DATE: December 8, 2020

SUBJECT: Palomino Fields Plat Division 4

TO: All Staff  
FROM: Justin Turnbull, County Surveyor   
DATE: December 7, 2020  
SUBJECT: Second County Survey Review of Final Plat LPF-20-000014 (Palomino IV)

Surveyed by LMH	Scale 1" = 100'
Drawn by Tml/FCS	Sheet 2 of 6
Checked by FCS	Project No. 18146

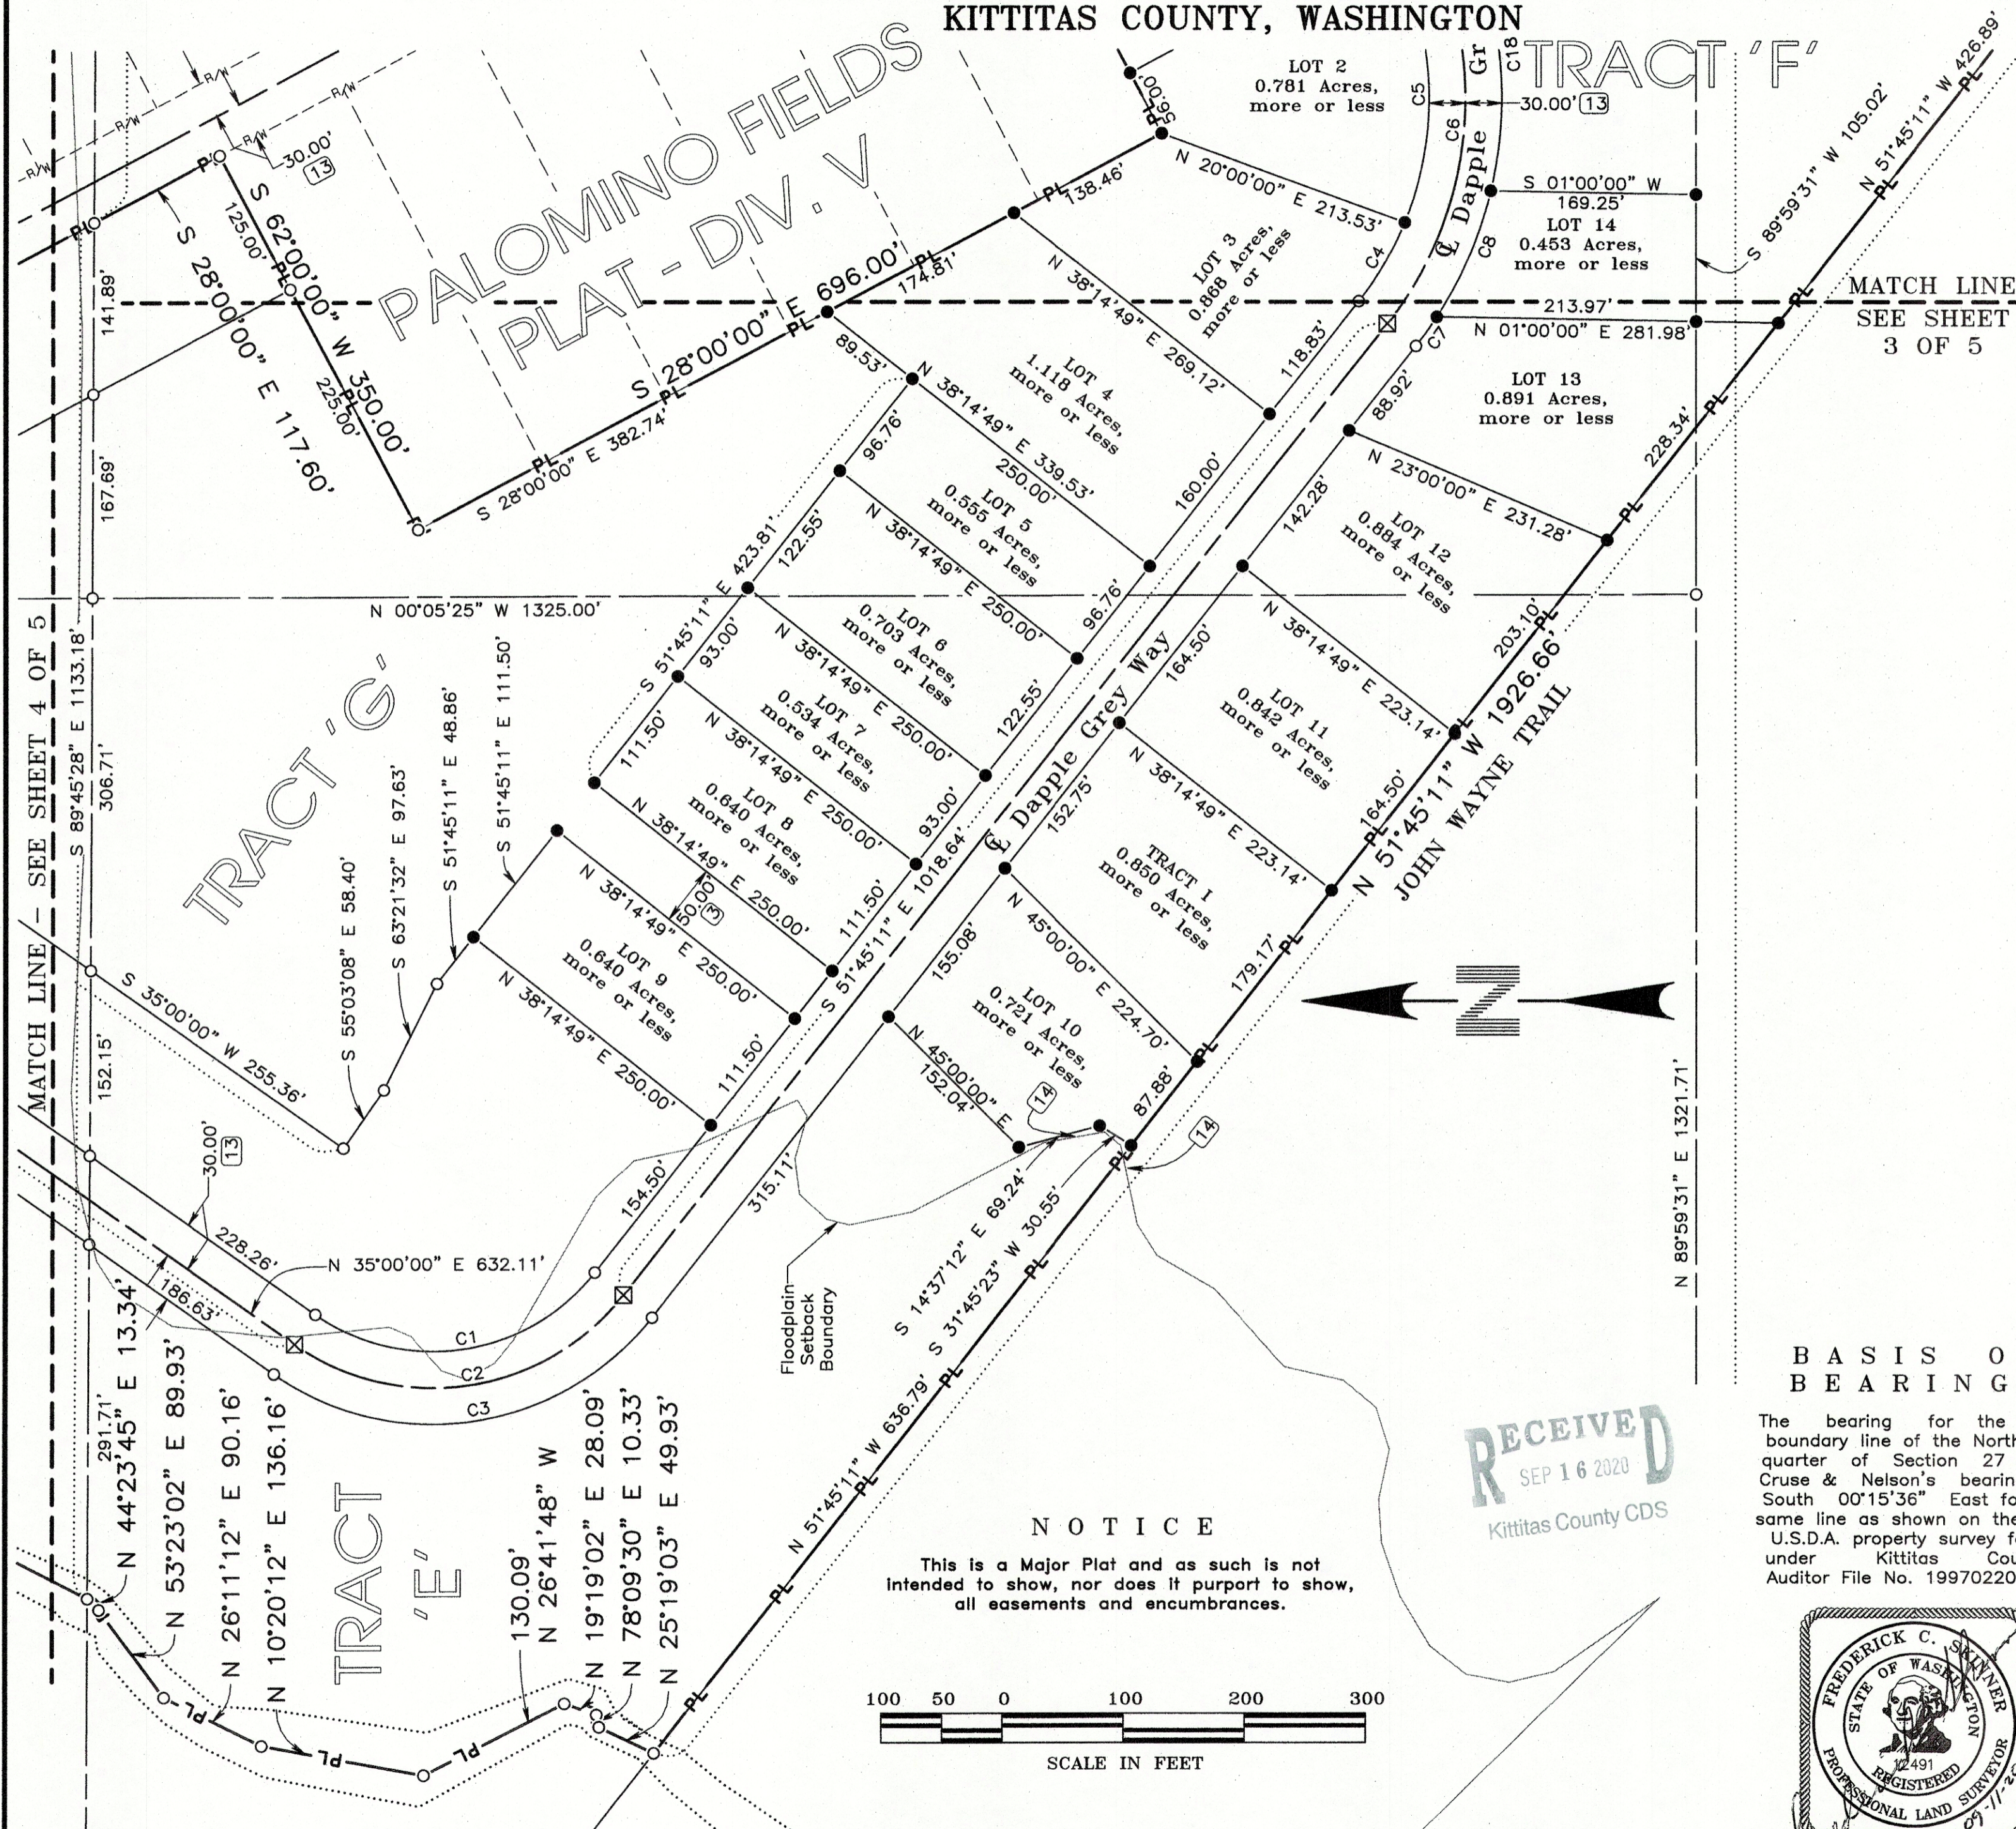
- a. Northernmost line of Tract F, shown as 146.15 feet in length, and appearing on sheet 3
- b. Easternmost line of Tract F, shown as 482.88 feet in length, appearing on sheet 3
- c. Curve on East boundary of Tract H, shown as C17 on sheet 4
- d. Curve of the East boundary of Tract e, shown as C3 on sheet 2

1. Note 13 is shown as reference to existing right of ways. Note 13 calls out “for emergency purposes” and is likely not relevant for primary access roads. This appears on multiple pages
2. Tract ‘H’ should be labeled

LCU, INC.	
Surveyed by LMH	Scale 1" = 100'
Drawn by Tml/FCS	Sheet 3 of 6
Checked by FCS	Project No. 18146

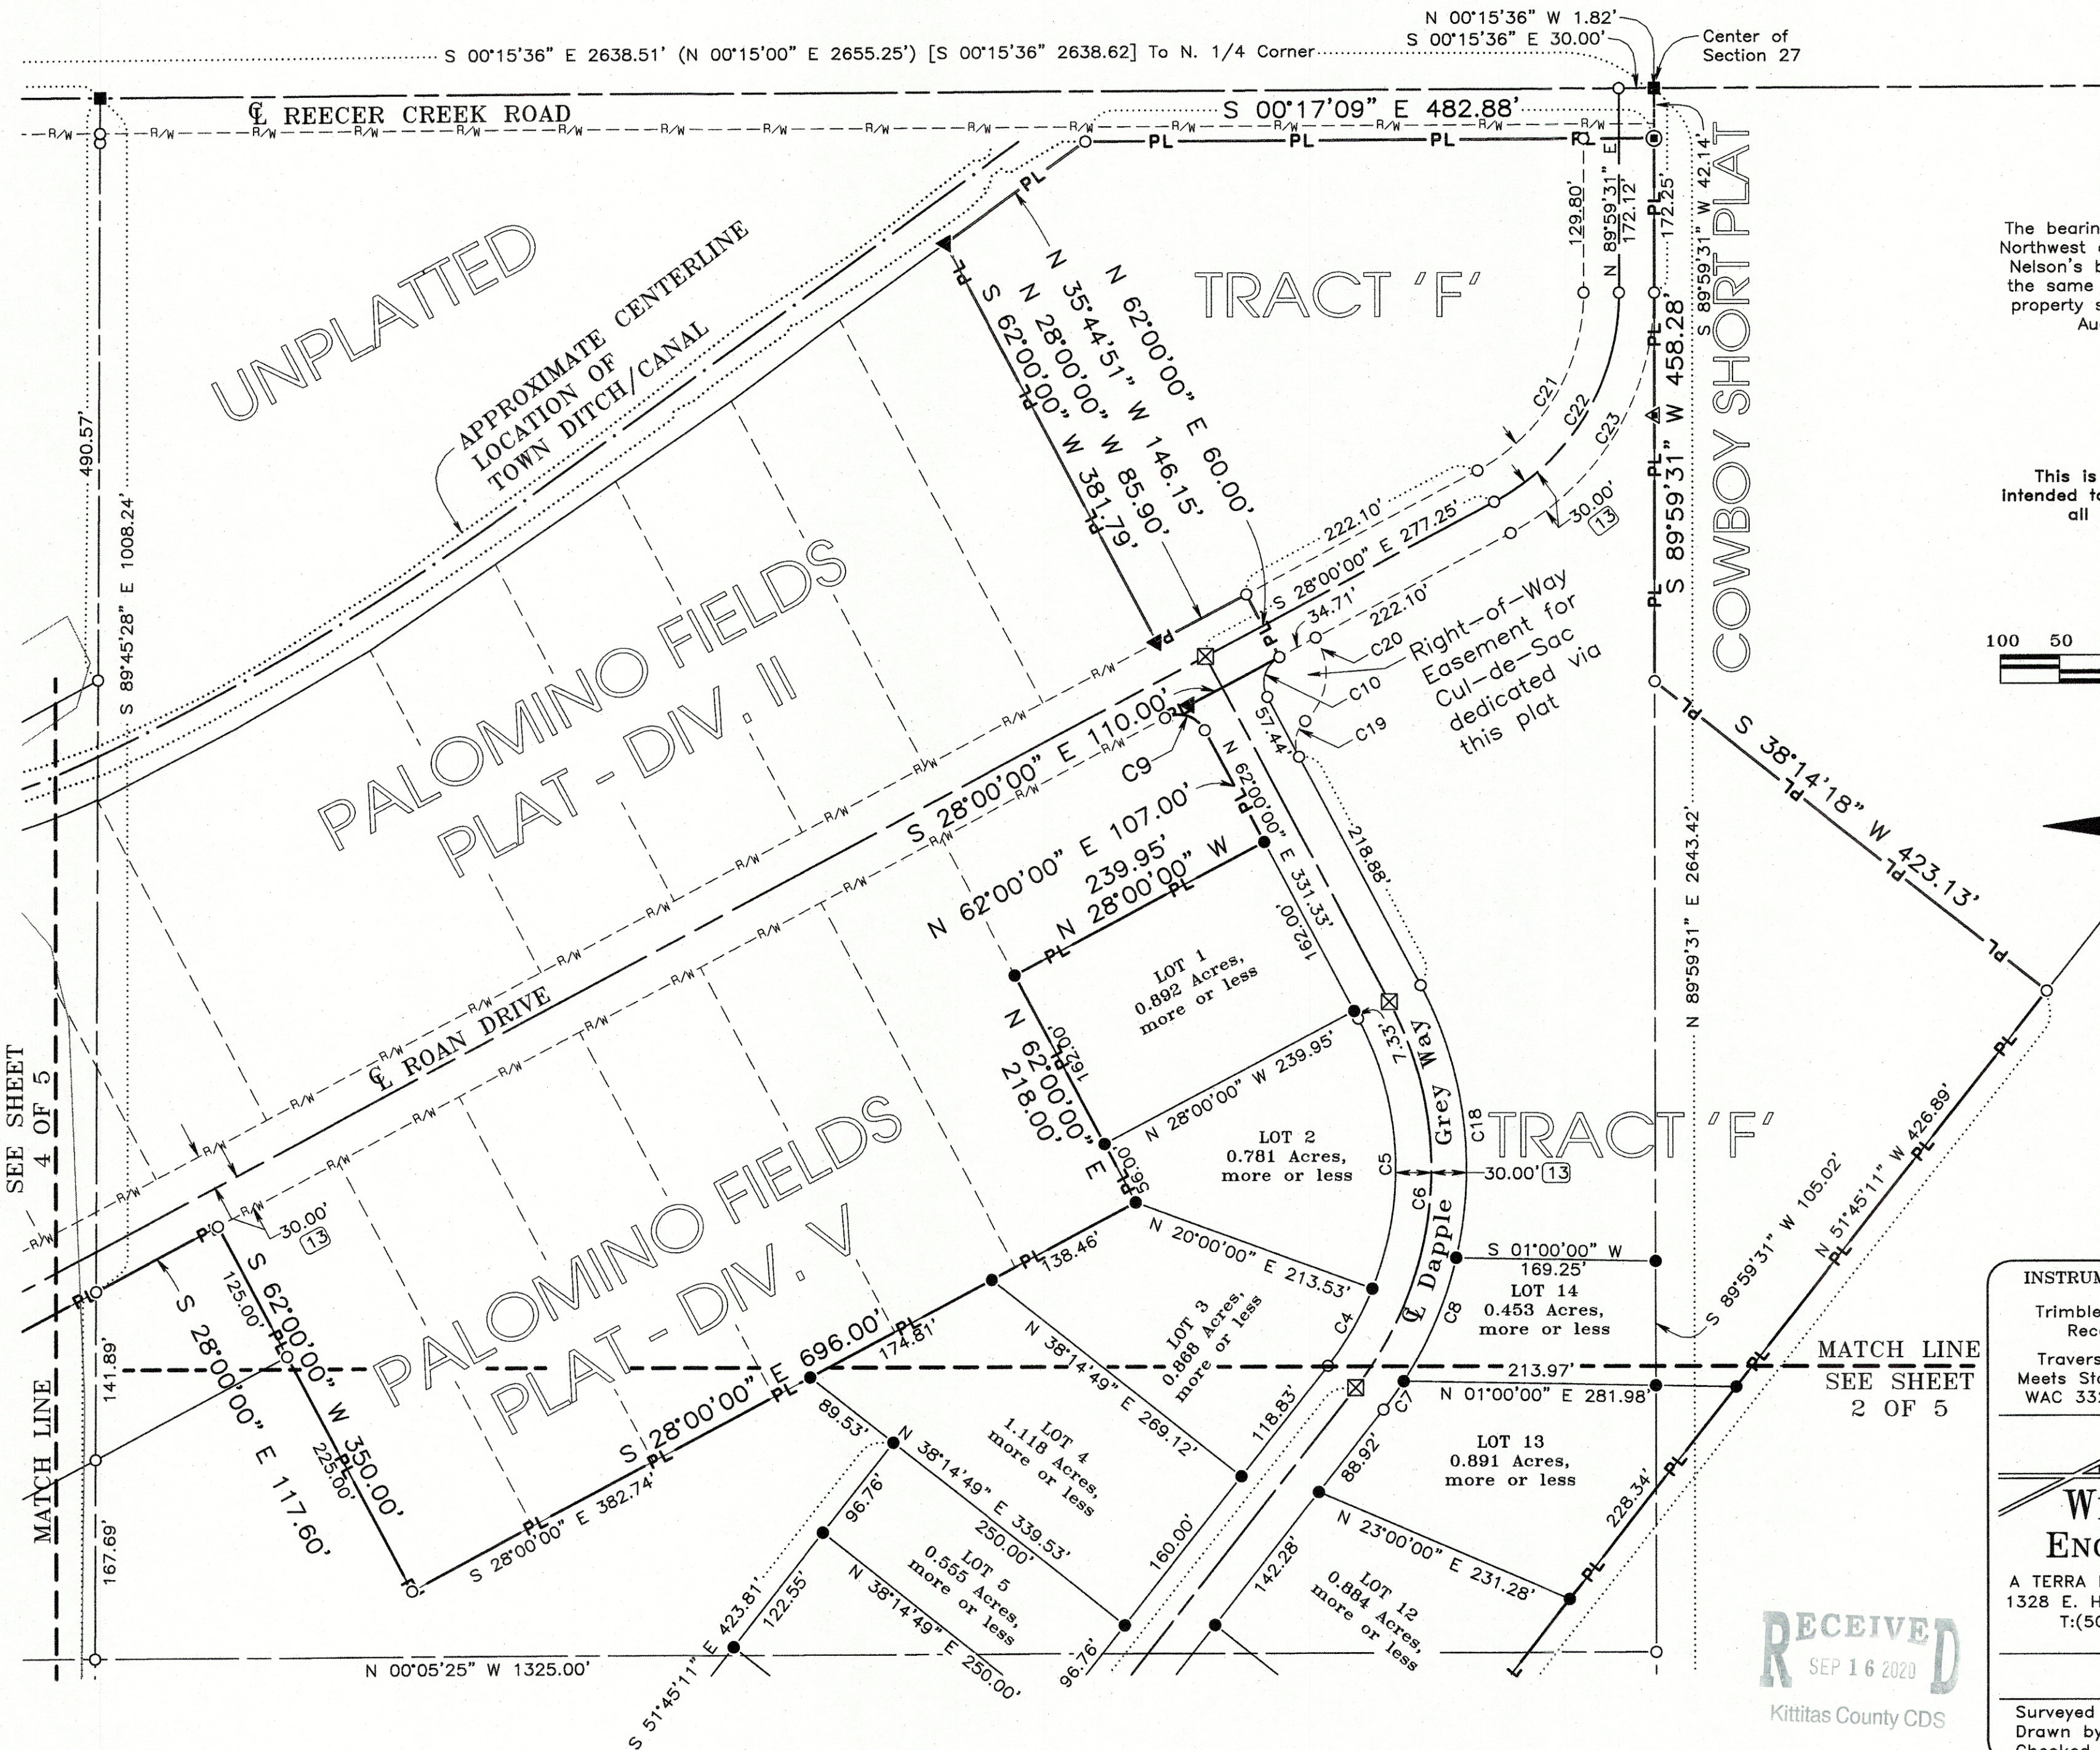
1. There is some confusion regarding the cul-de-sac area. WPE has identified this as a Right-of-Way easement. Please show this as right of way dedicated, and remove the included area from the total area of Tract F. Please also include the portion of the right of way on the East side of Road drive, as shown on Palomino III and V.
